**WELWYN HATFIELD BOROUGH COUNCIL  
EXECUTIVE DIRECTOR - PLANNING, PUBLIC PROTECTION AND GOVERNANCE**

**DELEGATED APPLICATION**

**Application No:** 6/2021/1791/VAR  
**Location:** Nyn Manor Vineyards Road Northaw Potters Bar EN6 4PQ  
**Proposal:** Variation of condition 4 (approved plans) on planning permission 6/2019/1813/FULL  
**Officer:** Mr David Elmore

**Recommendation:** Refused

JOB No.	2109
DWG No.	PL10F
SCALE	1/100 @A1
DATE	JULY 2019
DRAWN	PH
CLIENT

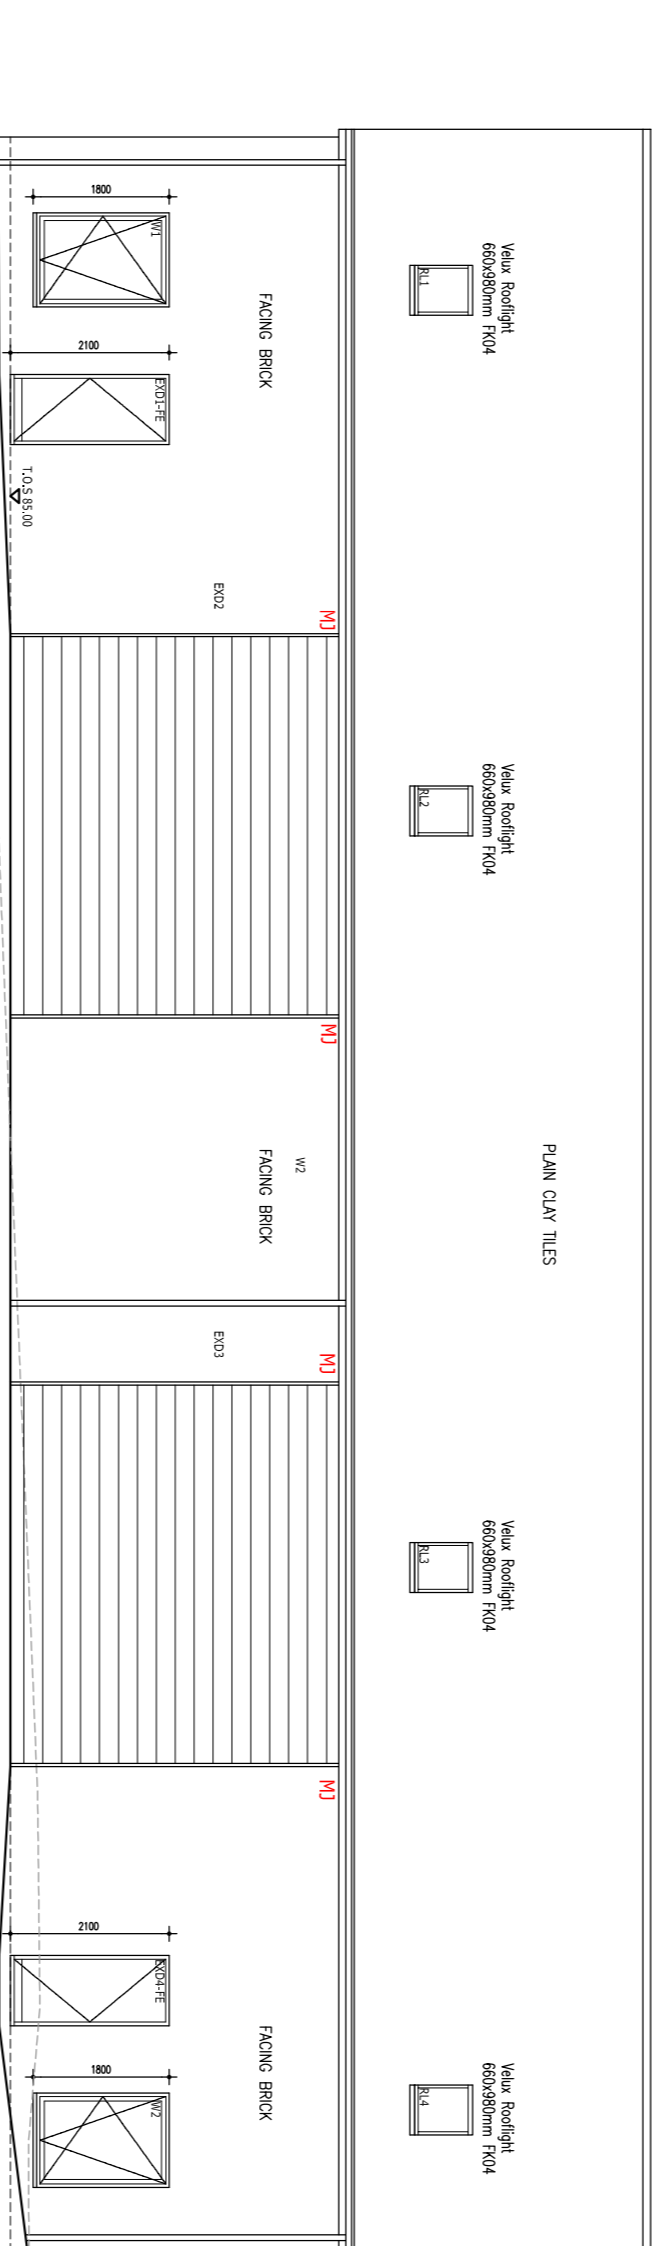
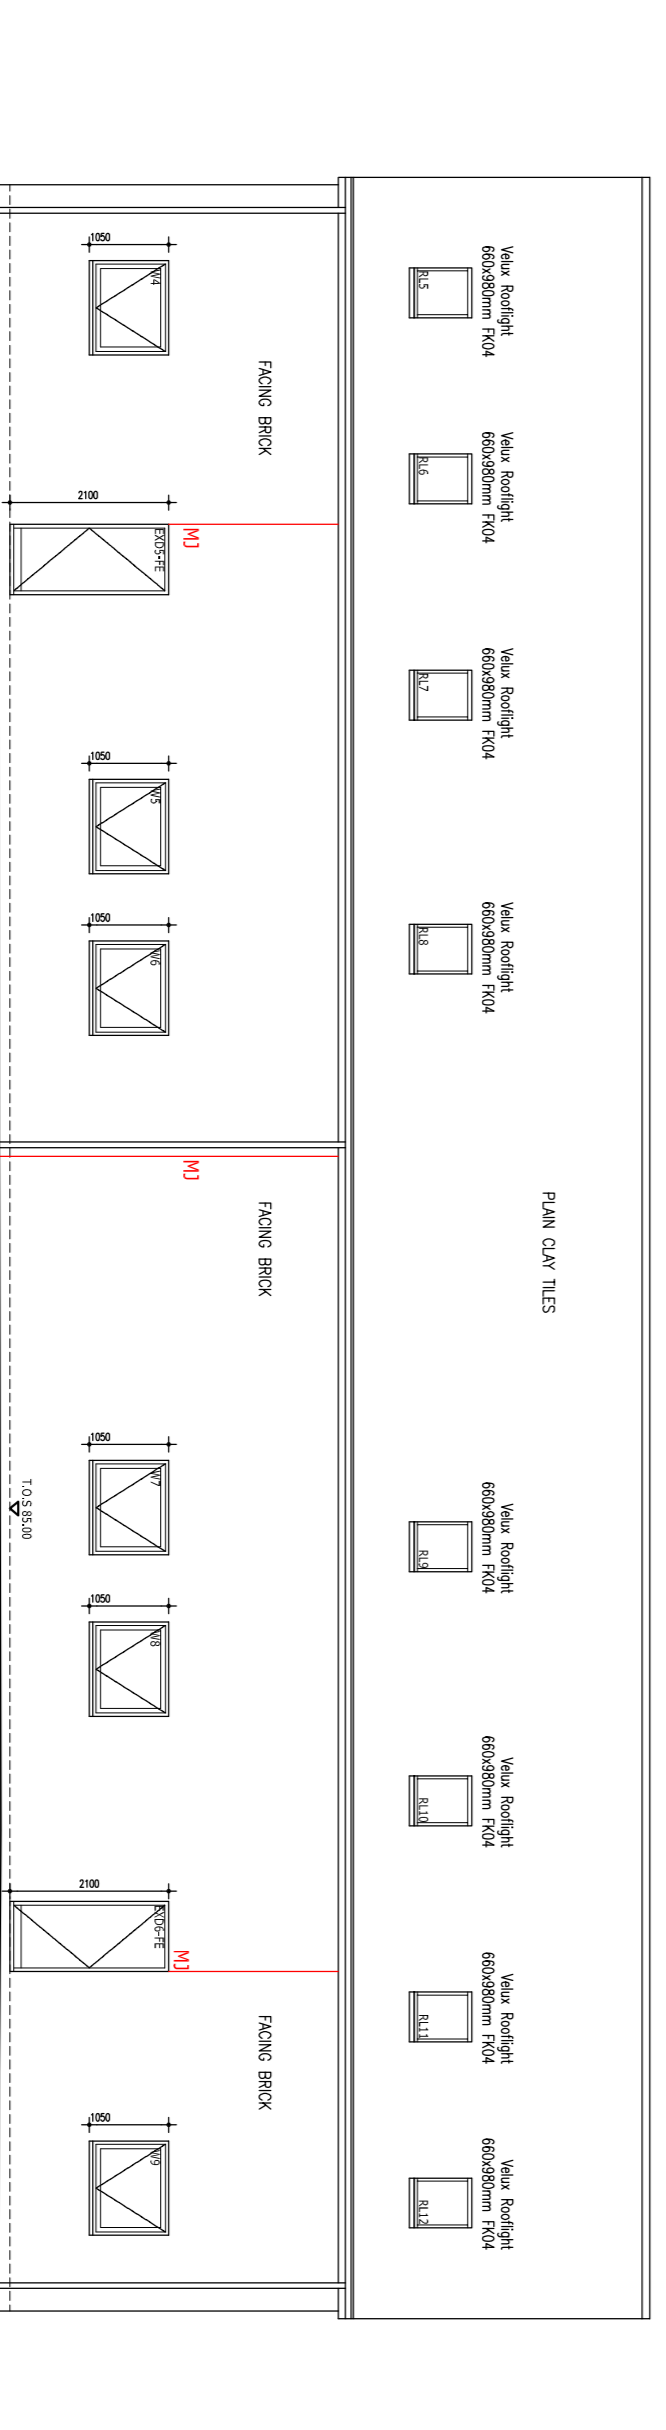
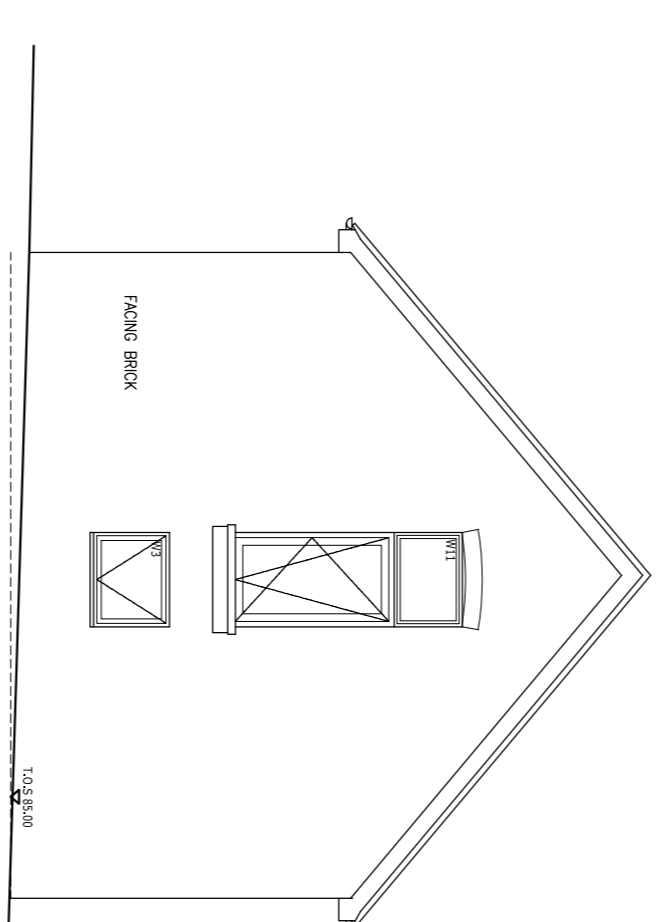
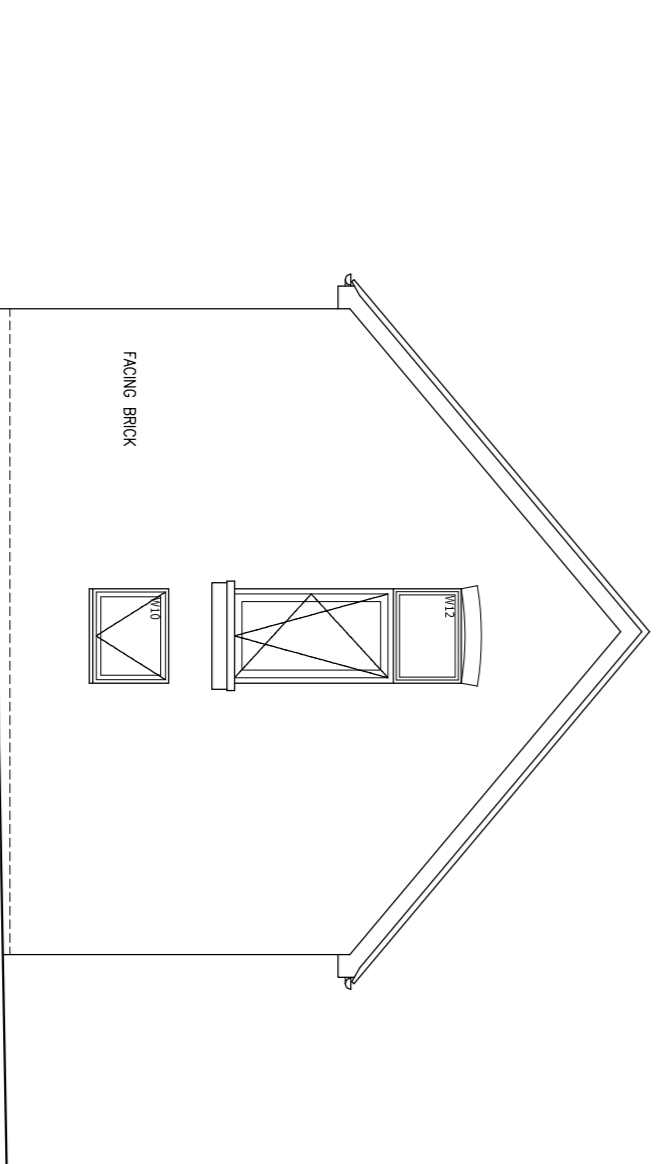
The glazed bi-fold doors which have been installed behind the roller shutters have a domestic scale and appearance. These features and the now total of eight roof lights on one roof slope are highly unusual for buildings in agricultural use and are normally witnessed on residential buildings.

While roof lights are included on the consented machinery shed, their quantity on each roof slope is markedly less than those now present on the ‘Old Barn Elevation’. The building as a whole now has an obviously residential character and appearance and gives the impression externally of two symmetrical dwellings.

It is also considered that the bi-fold doors would not provide ease of movement of agricultural machinery. This access and egress arrangement for such machinery is not practical or efficient.

Furthermore, it is noted that the end roof lights on the ‘Old Barn Elevation’ have been installed notably higher on the roof slope than the other roof lights which are all at the same height. This is very odd and does not support the main argument for the roof lights which is to reduce reliance on artificial lighting.
